Response to Planning application from Hertfordshire County Council (T and CP GDP Order 2015)

District ref: 6/2021/3422/MAJ
HCC ref: WH/11241/2022
HCC received: 2 March 2022
Area manager: Matthew Armstrong
Case officer: Chris Carr

SALISBURY SQUARE HATFIELD AL9 5AD

Notice is given under article 22 of the Town and Country Planning (Development Management Procedure) (England) Order 2015 that Hertfordshire County Council as Highway Authority recommends that permission be refused for the following reasons:

TITLE: REFUSE SWEEP PATH ANALYSIS

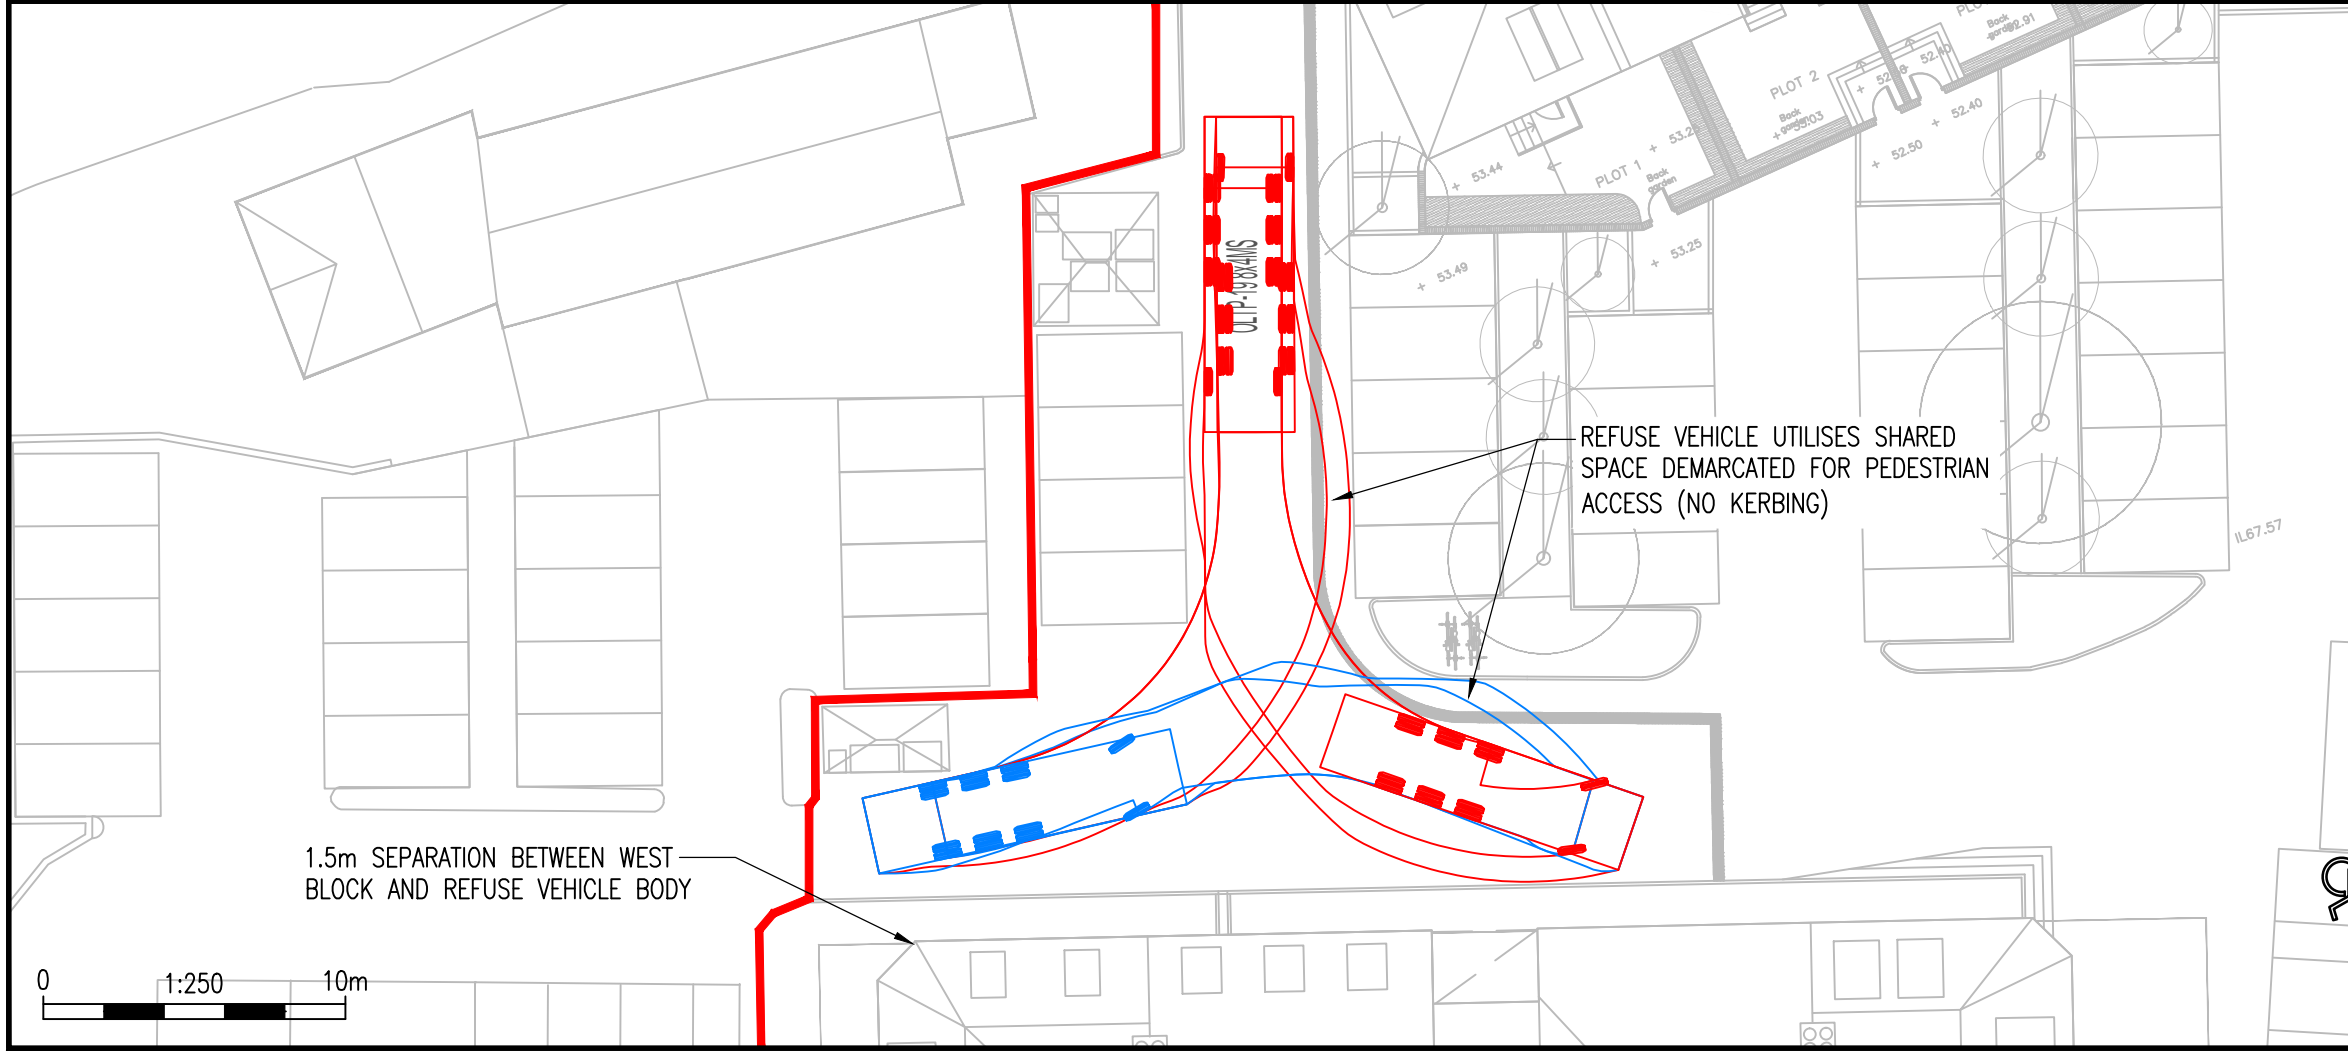
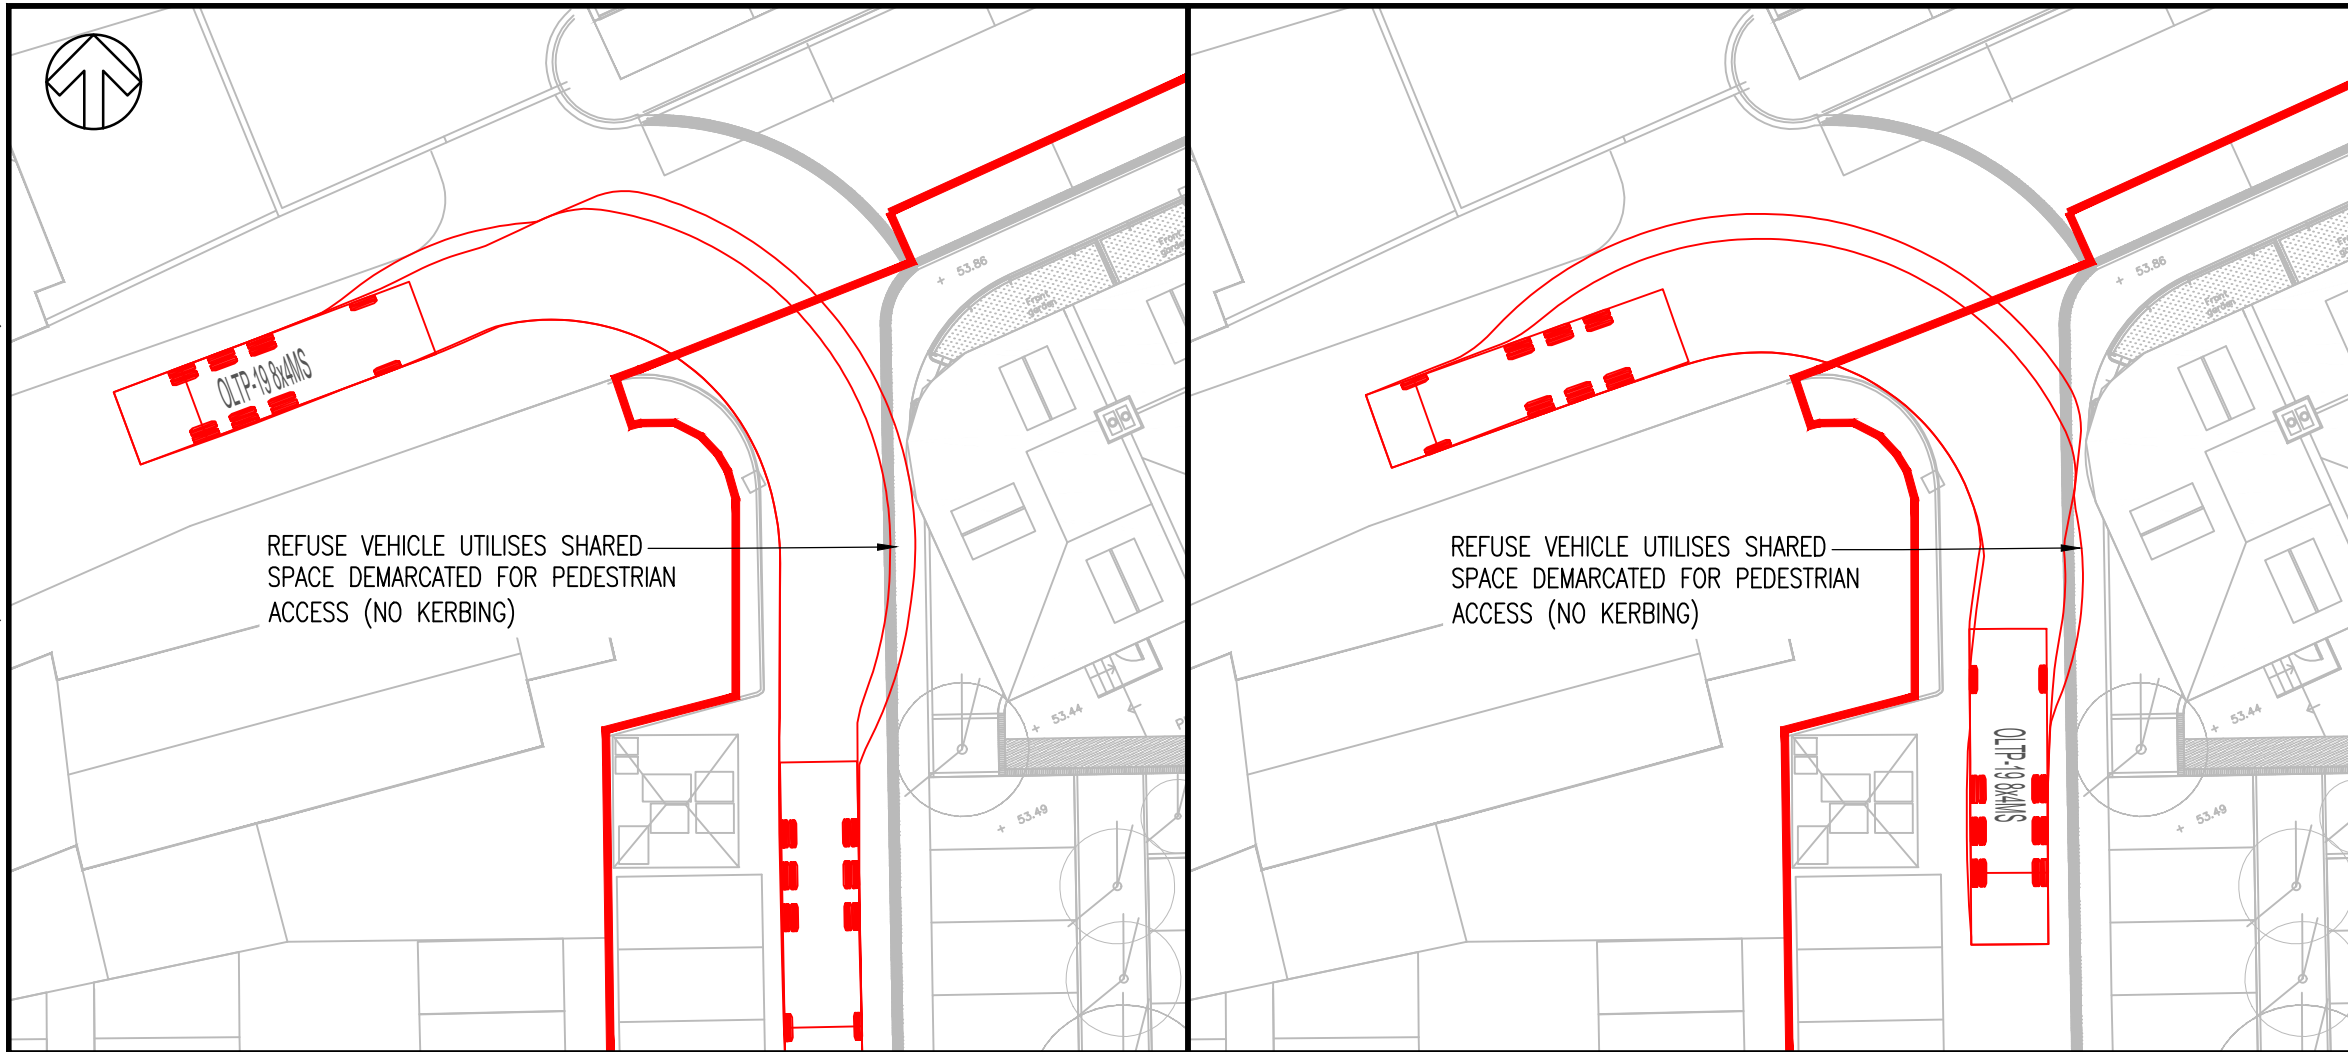
Swept path analysis has been undertaken at the vehicular access to the west of the houses and within the site using a 10.425m x 2.55m refuse vehicle. Servicing and refuse collection will also be undertaken via the vehicular access to the west of the houses and the internal road layout.

The swept path assessment identifies the footway access shall be overrun by the refuse vehicle. The swept path designs show the vehicle having to access the shared space to egress the site. Ideally such a movement would not be required and the design of the access modified to accomodate a refuse vehicle on the dedicated vehicular access road. However, it is appreciated these movements are slow moving and a low occurrence. Once evidence is supplied as to how movement of vehicles is to be accomodated during the site servicing, HCC shall conclude whether the swept path movements are acceptable.
